## Response To Submissions

To	Sara Roach	Page	1
CC	Elise Crameri		
Subject	Glebe Island Expo Response to Submissions		
From	Russell Yell		
File/Ref No.		Date	14-Feb-2013

The following tables list the transport and access related submissions received during exhibition of the Glebe Island Expo Development Application and the response to those submissions.

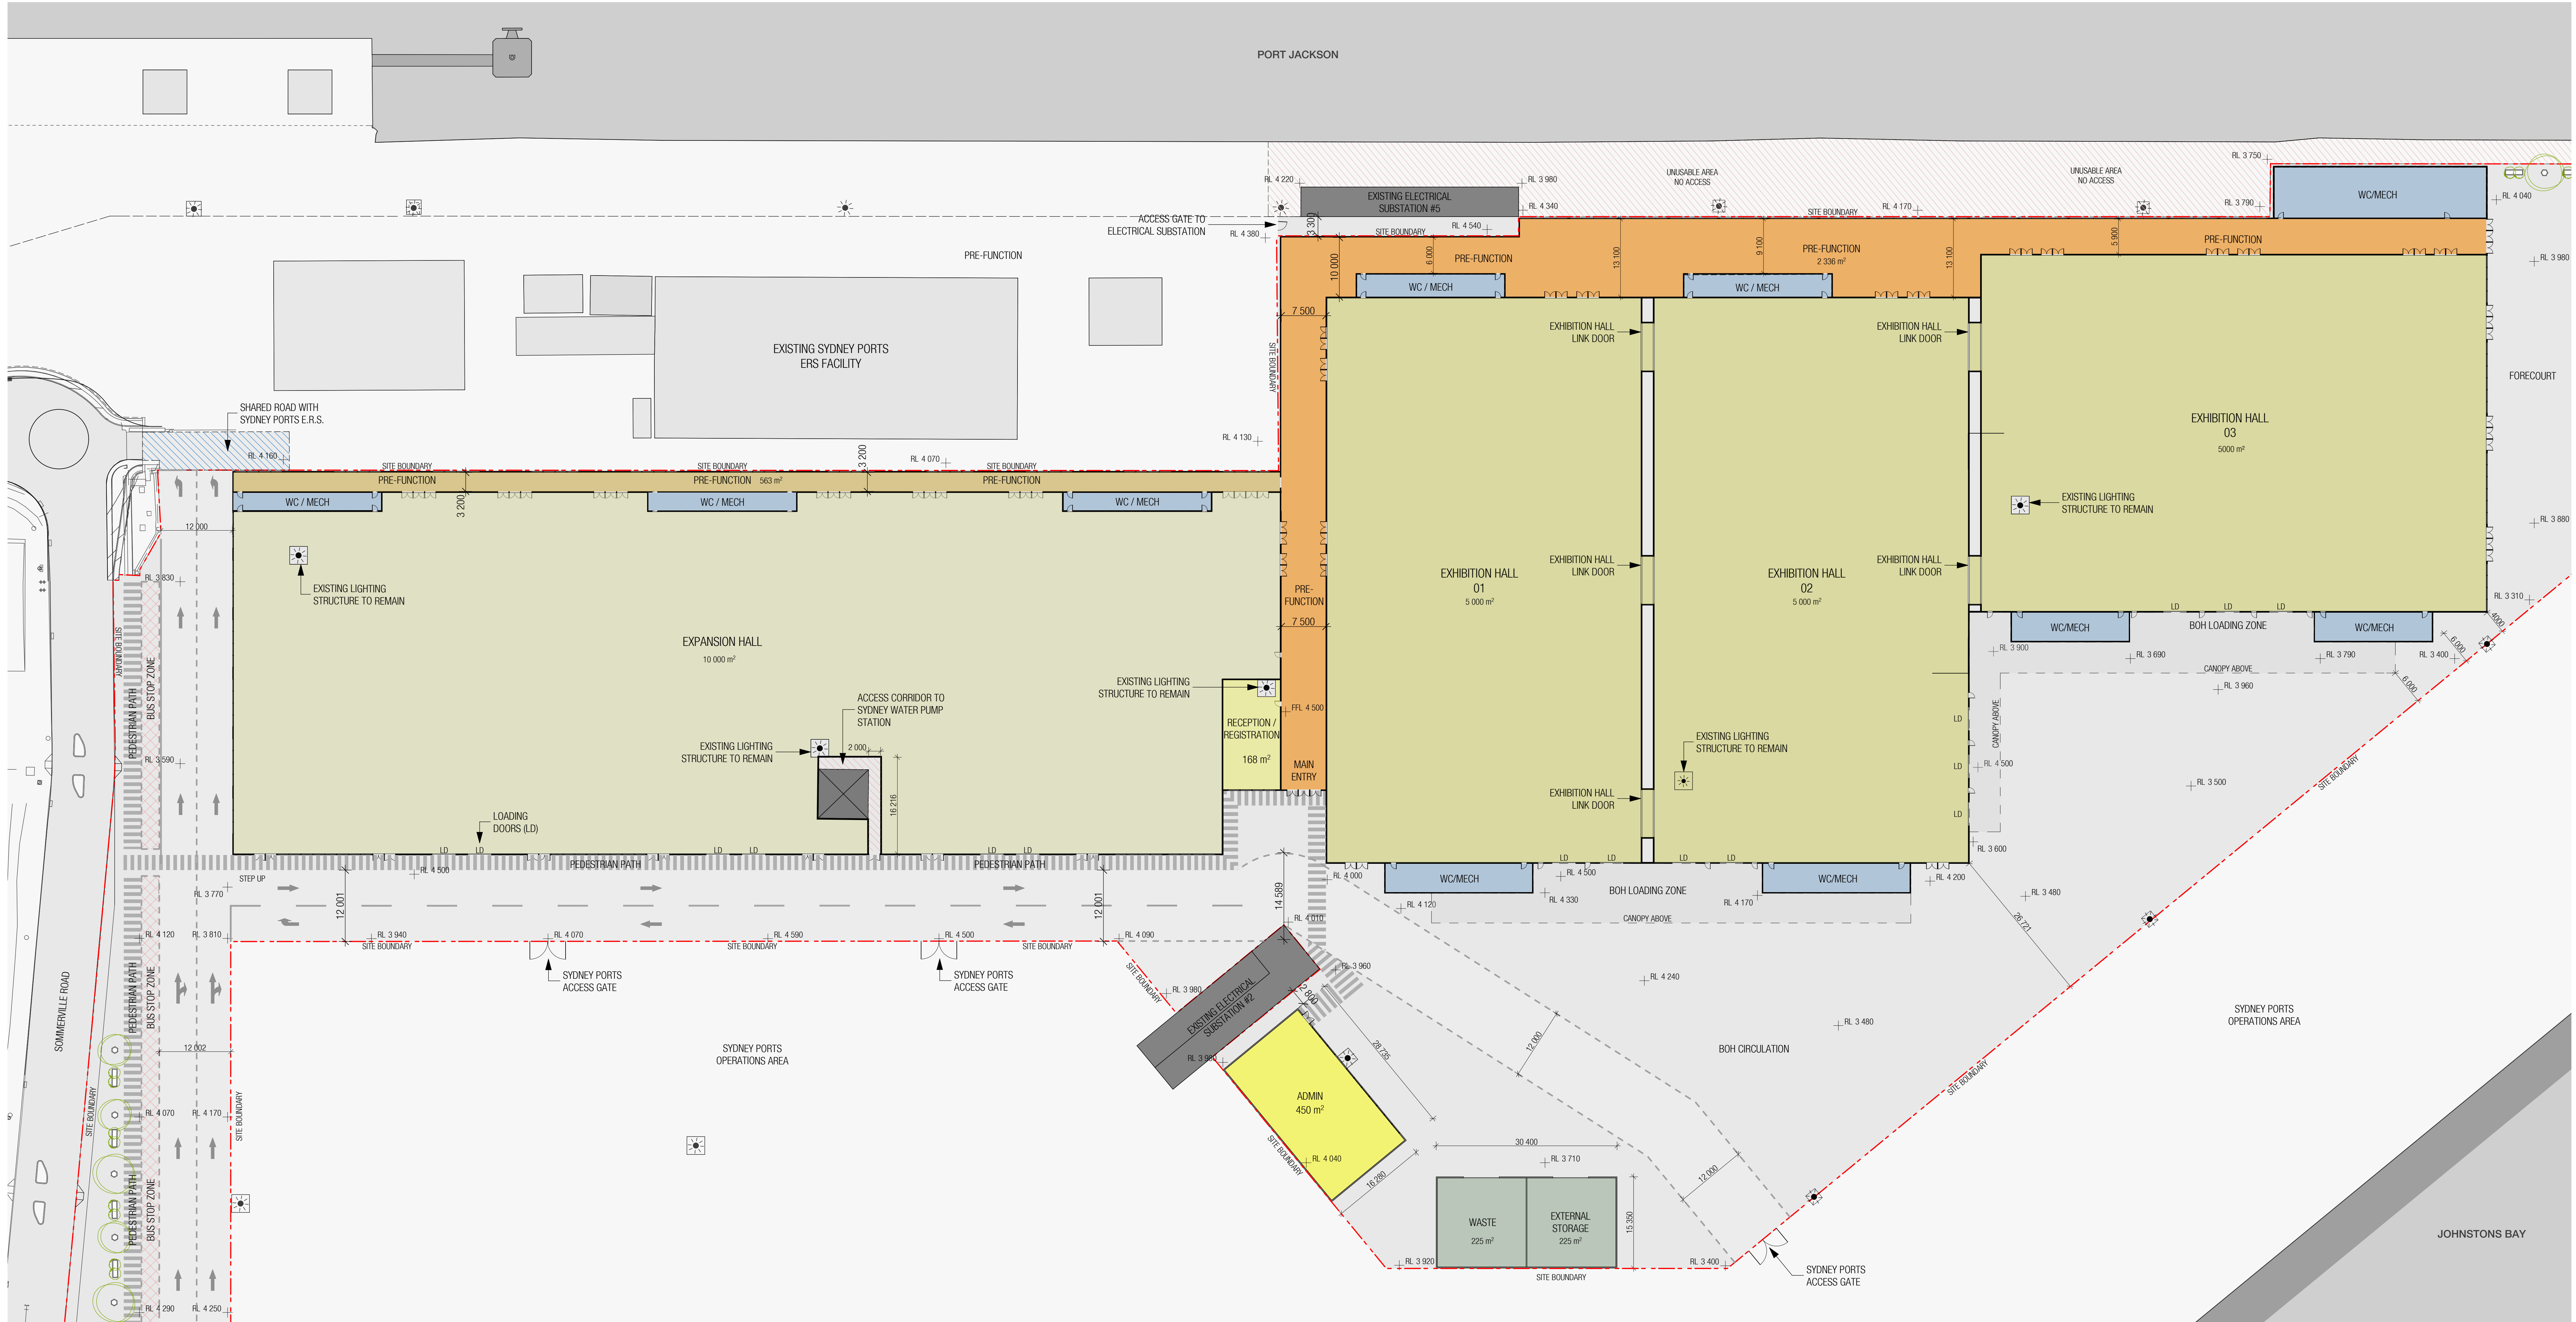
7.10		Other detail lacking in the DA includes methods of control for vehicle and taxi access.	The revised site layout plan provides a pickup/drop off point for cars and taxis and incorporates them into the internal plan.

CAR PARK A
SCALE 1:1000

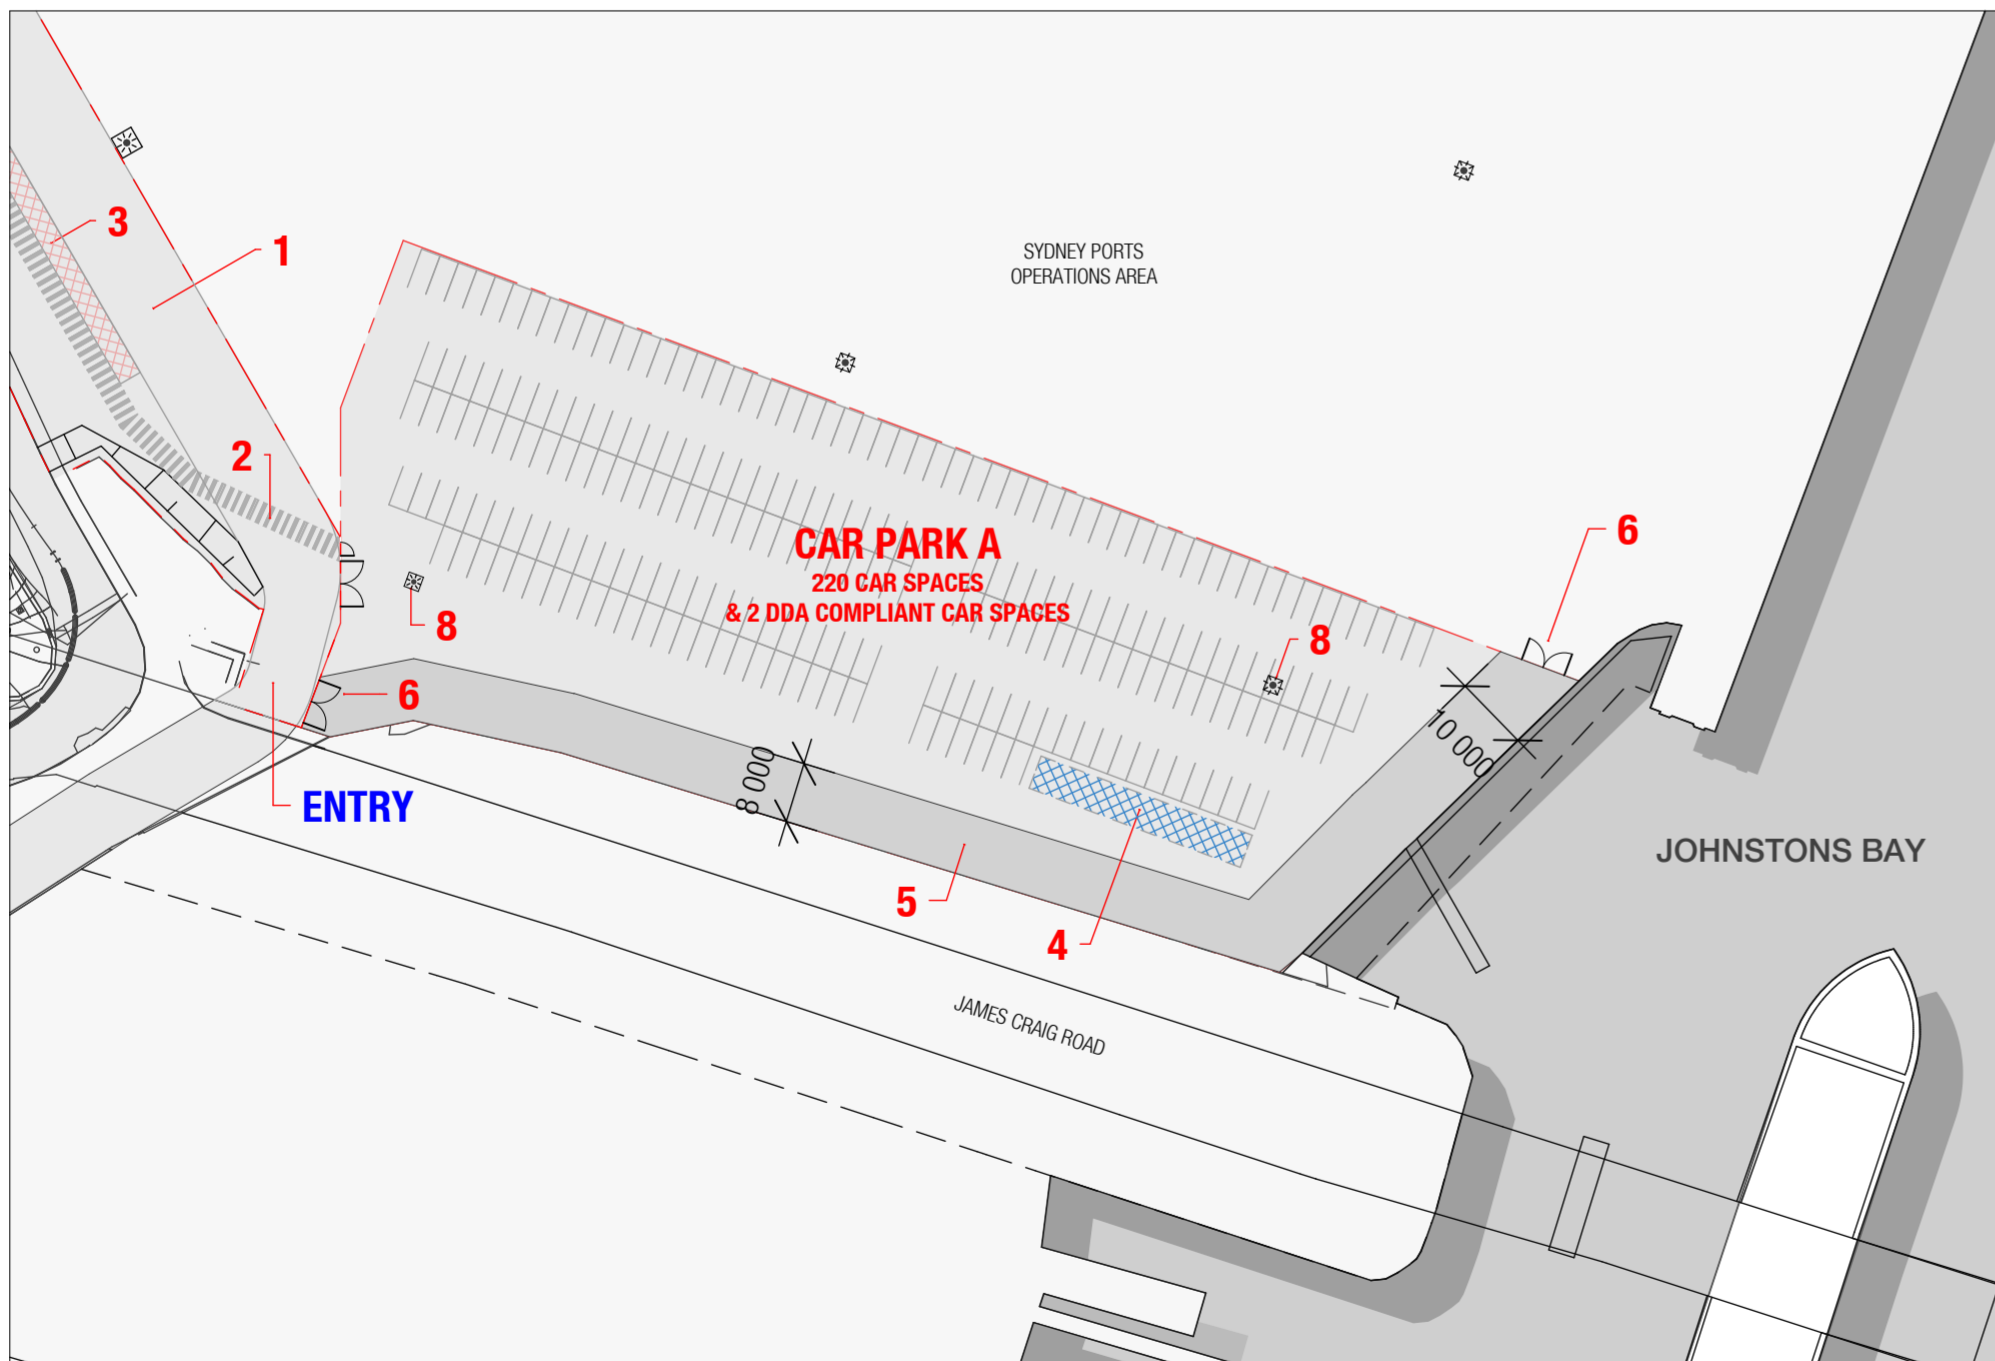
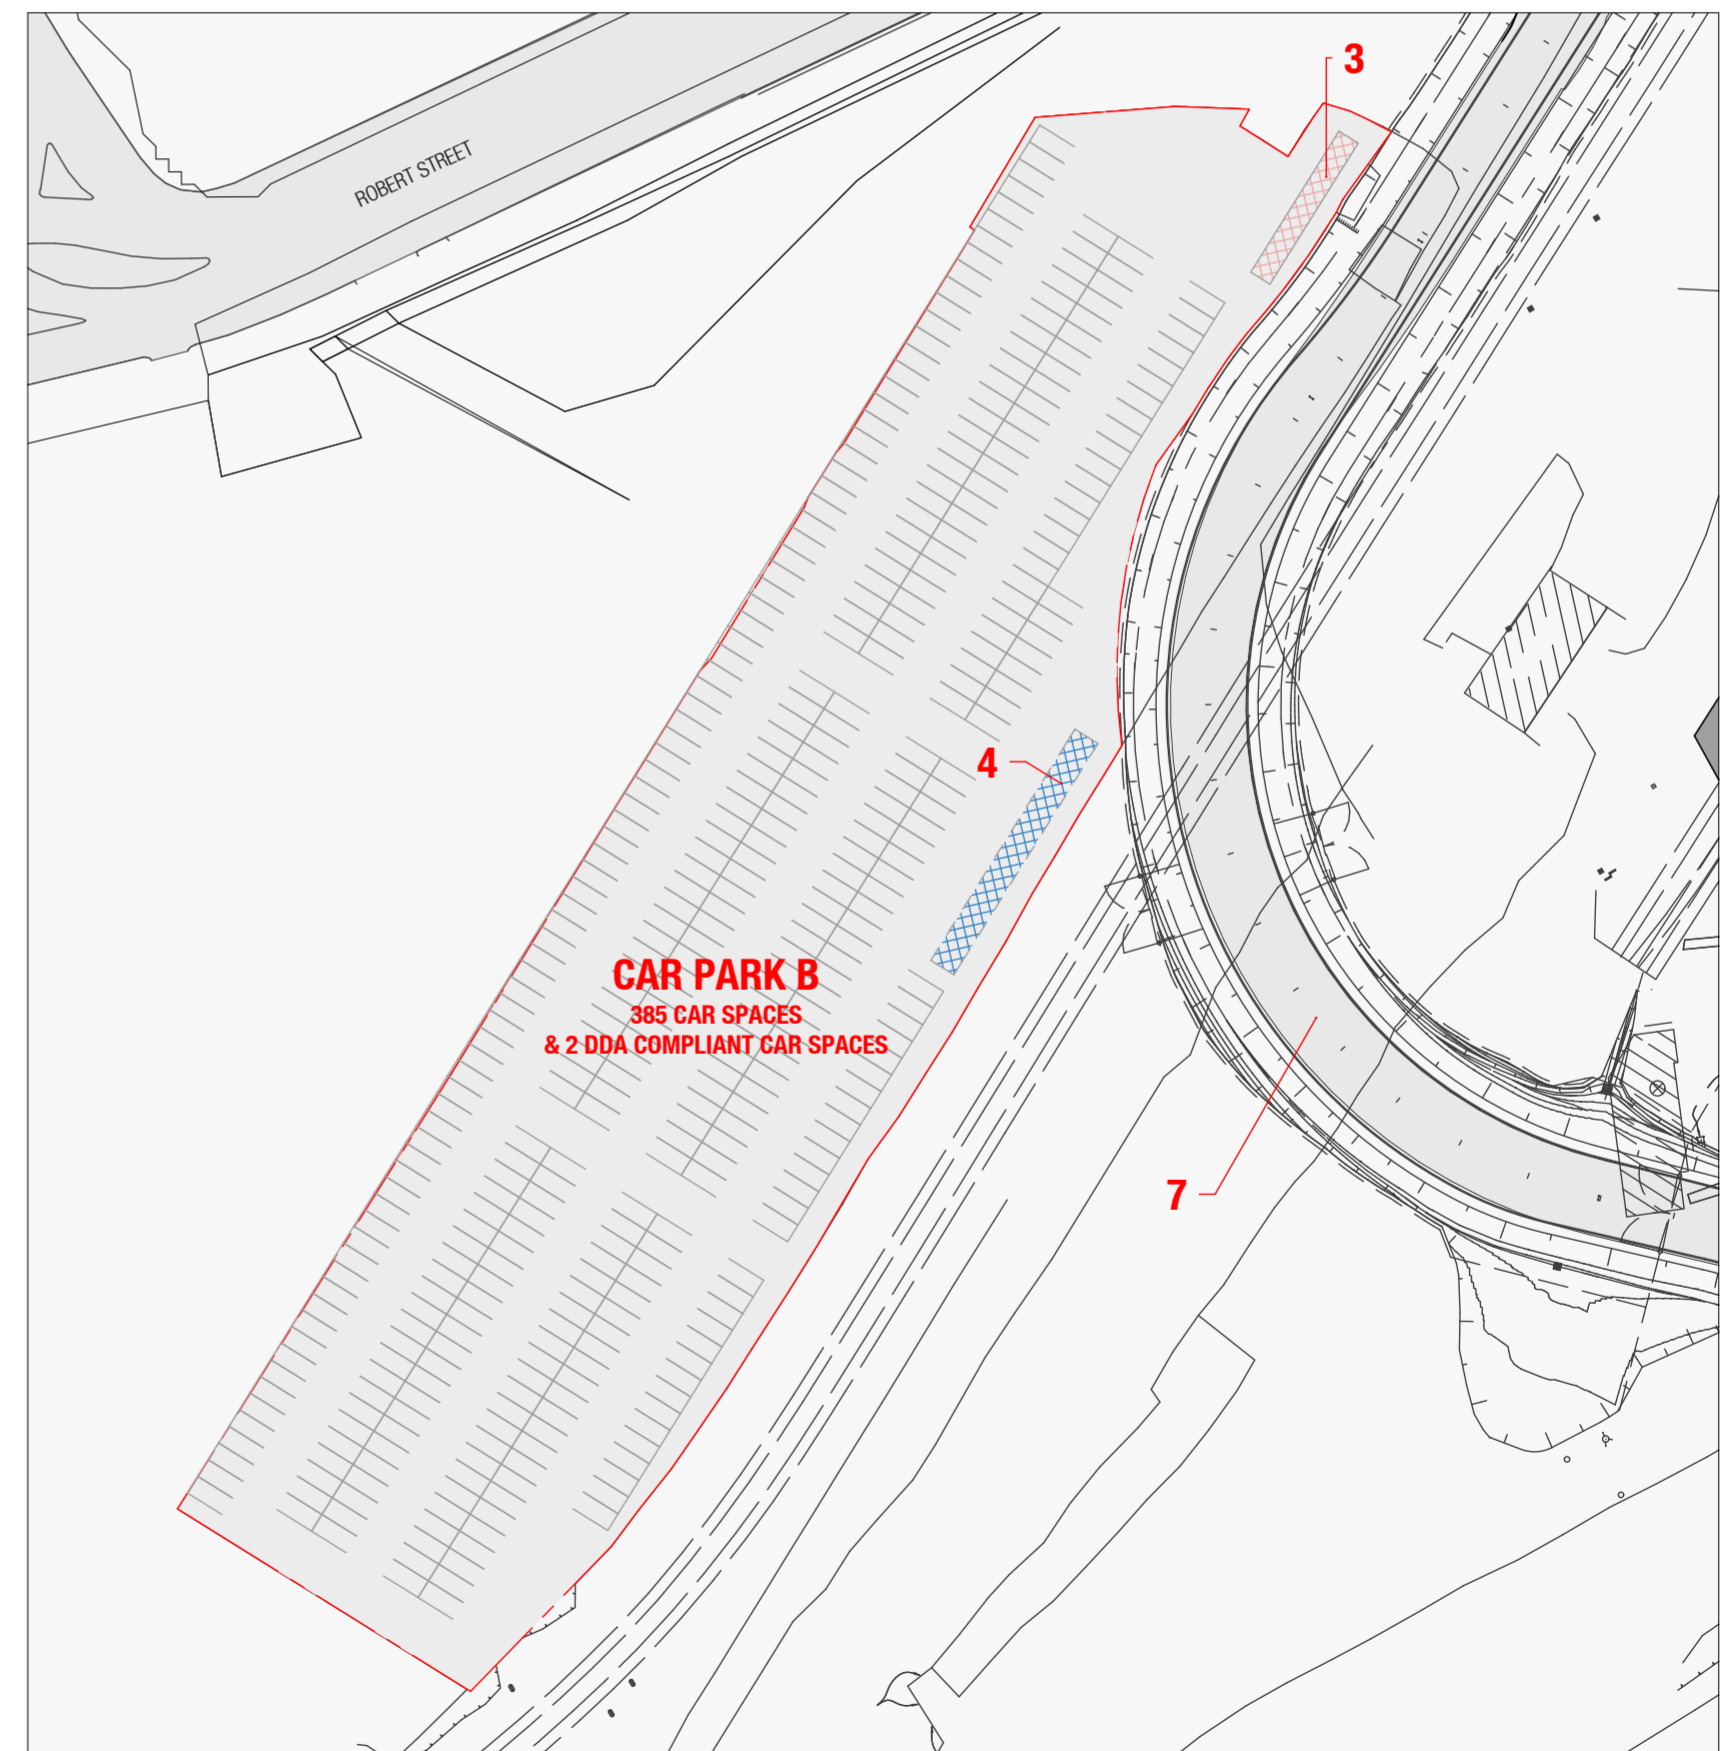
2.3		<p>Car Parking:</p> <ul style="list-style-type: none"><li>i. Sydney Ports will not permit the use of Car Park A for reasons relating to safety concerns around conflict between pedestrians, light vehicle traffic and heavy vehicle port traffic.</li><li>ii. Sydney Ports cannot guarantee the availability of car parking areas at White Bay 4 &amp; 5.</li><li>iii. Confirmation that the currently undeveloped land approved for development of the White Bay CPT Long-Term car park can be made available for use as parking for the Interim Facility.</li></ul>	<p>AECOM acknowledges that the proposed Car Parks A and C are no longer available. Alternative locations have been agreed upon and can be seen in the final site plan issued by Woods Bagot.</p>

3.0 Sydney Harbour Foreshore Authority																								
3.1		<p>Car Park B extends onto land that forms part of the White Bay Power Station, owned by the Authority. Further consultation is required on :</p> <ul style="list-style-type: none"><li>i. Extent of land required</li><li>ii. Terms of a lease/licence agreement for use of this land; and</li><li>iii. Details of proposed access arrangements for temporary public events at the White Bay Power Station</li></ul>	<p>Information on the space required for car park B (which is now referred to as Car Park A) can be seen in drawing A2700 issued by Woods Bagot.</p> <p>The lease/licence agreement for this land is not considered in this response.</p> <p>Detailed design of the car park access and access requirements for the White Bay Power Station have not yet been finalised.</p>
